Proposal: Temporary permission for 5 year period for use of land for leisure and recreation purposes; siting of associated transient structures; erection of means of enclosure; surfacing and associated works

Location: Upper Mills, Canal Side, Slaithwaite, Huddersfield

Waterway: Huddersfield Narrow Canal

PROJECT TITLE IGLU SLAITHWAITE, HD7 5AH		
DRAWING TITLE PROPOSED SECTION AA		
DATE 05.09.2025	DRAWN JH	SCALE 1:50 + 100
PROJECT P0097	NUMBER P_AS_AA	REVISION 04

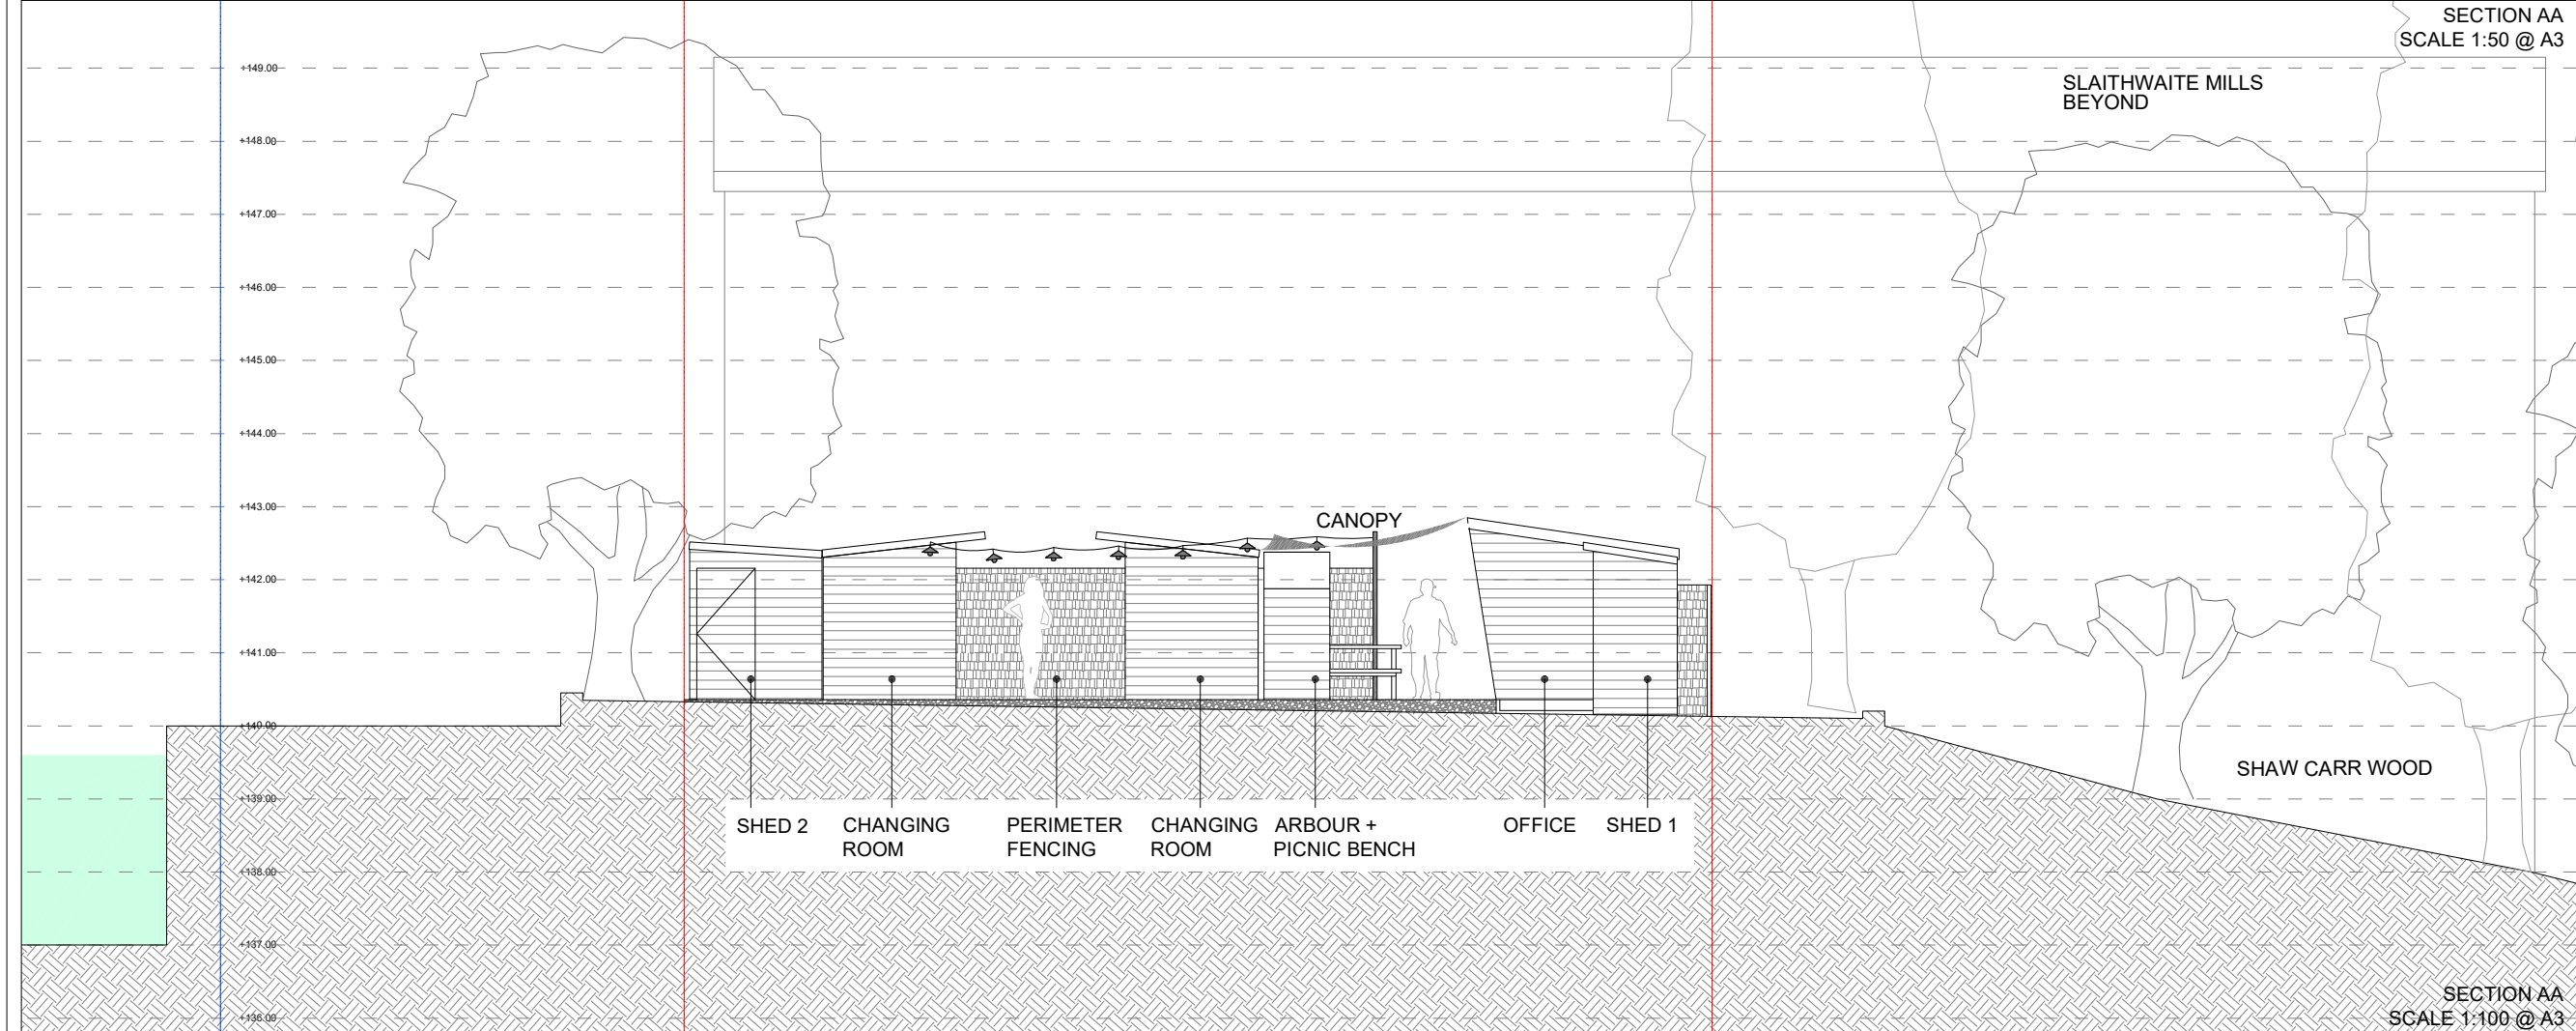
There is potential intervisibility between the canal and the proposed development due to the proximity of the works to the canal towpath, and the varying density of existing vegetation.

The structure are low in height and have a small footprint. However the varying heights and materials could have some negative impact on the outlook and setting as seen from the canal.

We request that consideration should be given to the installation of a native planting buffer as an effective screen to mitigate the impact of views of the rear elevations of buildings and fencing treatment.
